SSD-6093 – Bindaree Beef Rendering and Bio-digester Plants - Public Exhibition

ATTACHMENT 1 – KEY ISSUES IDENTIFIED IN EPA REVIEW OF PUBLICLY EXHIBITED EIS FOR SSD-6093 – BINDAREE BEEF RENDERING AND BIO-DIGESTER PLANTS

BINDAREE BEEF PROPOSED BIODIGESTER AND RENDERING PLANT
SECOND ADDENDUM TO EPA'S SUBMISSION ON EXHIBITED EIA
AIR QUALITY – RECOMMENDED CONDITIONS OF CONSENT

Figure 2-2: Sensitive Receptor Map [Mitchel Hanlon]

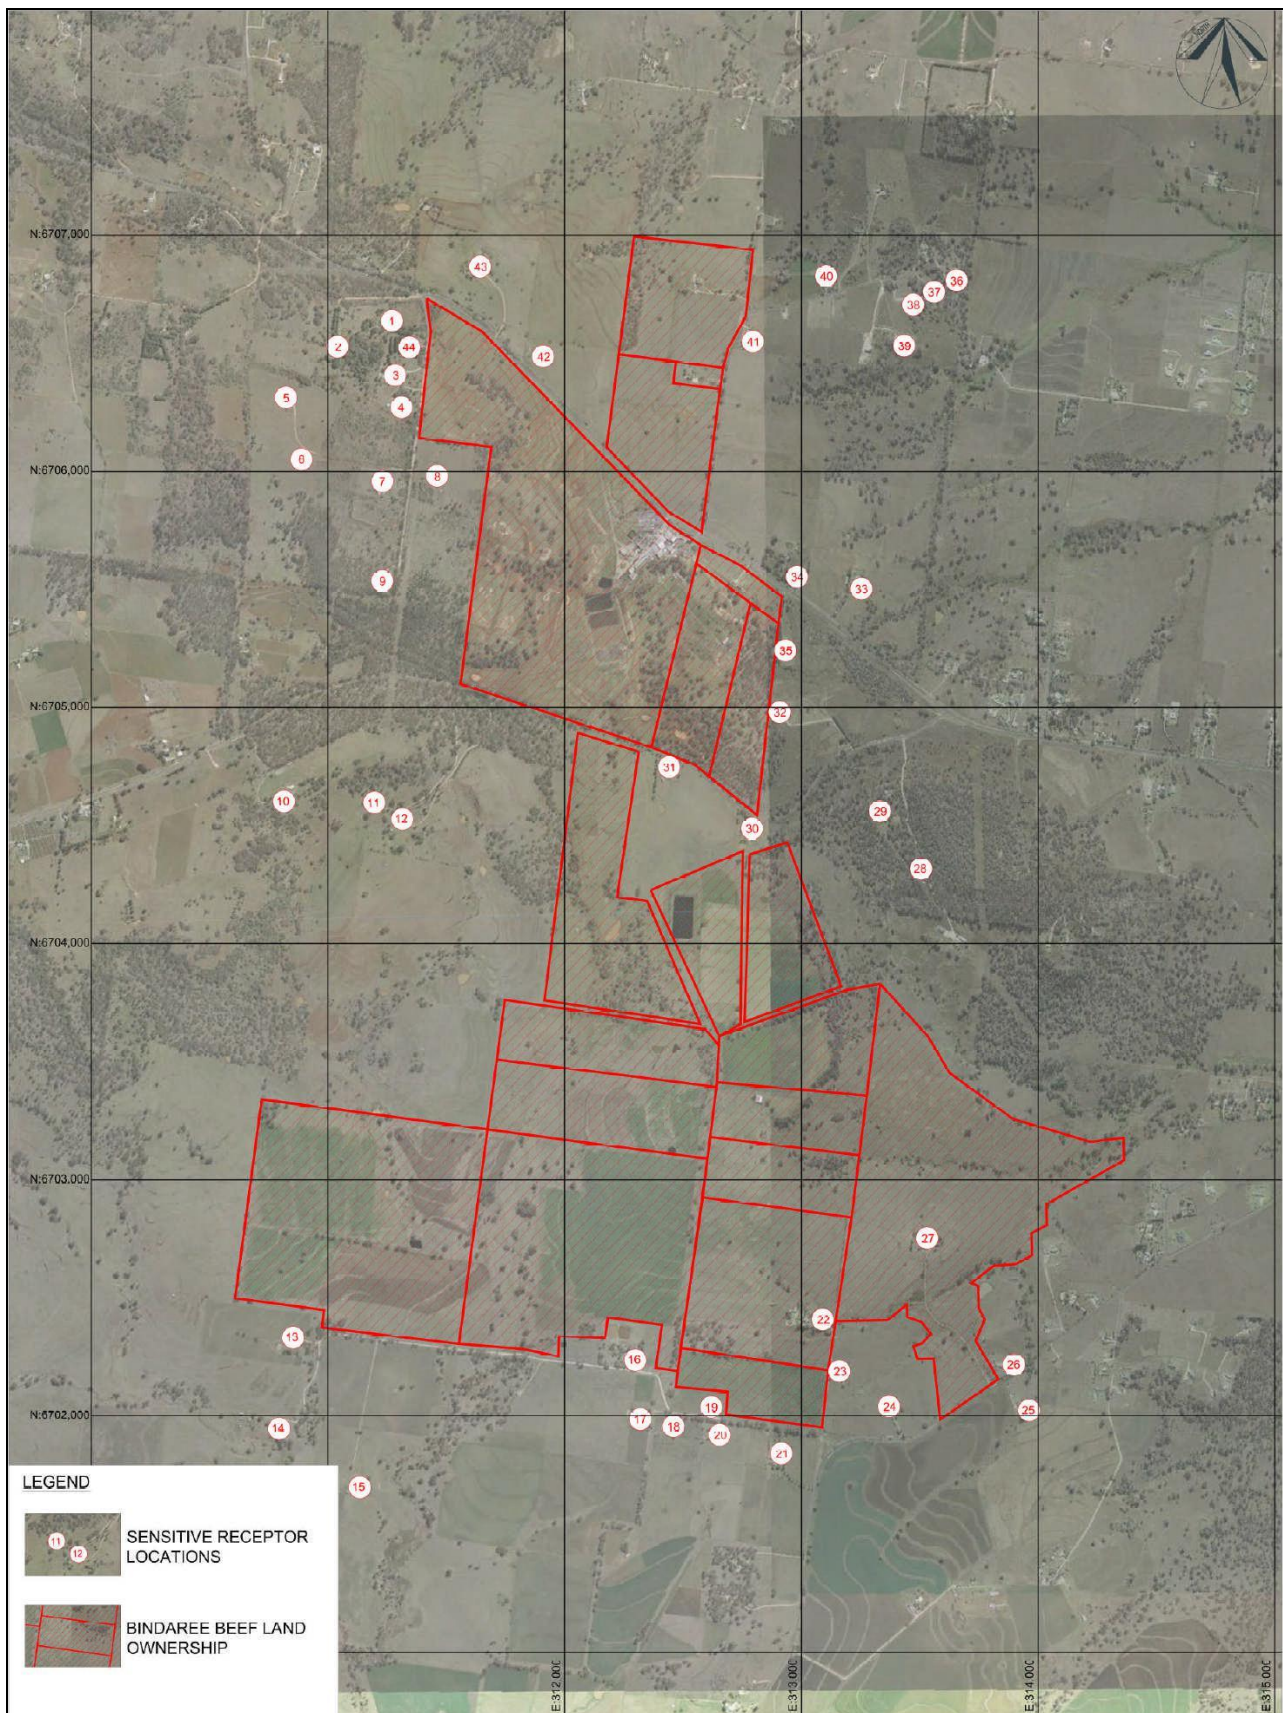
In its adequacy comments, the EPA requested the predicted odour impacts at nearest sensitive receptors be provided in tabular form. Table 8-1 in VIPAC final AQA includes the predicted odour concentration at each of the nearest sensitive receptors. However, receptors 43 and 44 appear to have been excluded from Table 8-1.

Recommendation: EPA recommends the proponent is requested to update Table 8-1 to include sensitive receptors 43 and 44.

Location 4	The residence on the property located at 22 McNeils Road, Inverell, Lot 3 DP252411 marked as Receptor 44 on Figure 2-2 in the document titled " <i>Bindaree Beef EIS – Noise Assessment</i> " dated 11 June 2014 by Vipac Engineers and Scientists	35	35	35	45
Location 5	The residence on the property located at 7360 Gwydir Highway, Inverell, Lot 5 DP831434 marked as Receptor 42 on Figure 2-2 in the document titled " <i>Bindaree Beef EIS – Noise Assessment</i> " dated 11 June 2014 by Vipac Engineers and Scientists	35	35	35	45
Location 6	The residence on the property located at 581 Fernhill Road, Inverell, Lot 1 DP1086623 marked as Receptor 41 on Figure 2-2 in the document titled " <i>Bindaree Beef EIS – Noise Assessment</i> " dated 11 June 2014 by Vipac Engineers and Scientists	35	35	35	45
Location 7	The residence on the property located at 7204 Gwydir Highway, Inverell, Lot 1 DP617431 marked as Receptor 34 on Figure 2-2 in the document titled " <i>Bindaree Beef EIS – Noise Assessment</i> " dated 11 June 2014 by Vipac Engineers and Scientists	35	35	35	45

Table 8-1 in VIPAC (2014b) includes the predicted odour concentration at each of the nearest sensitive receptors. Receptors 43 and 44 were excluded from Table 8-1 and EPA requested Table 8-1 be updated to include sensitive receptors 43 and 44. Table 8-1 in Vipac (2014d) includes sensitive receptors 43 and 44.
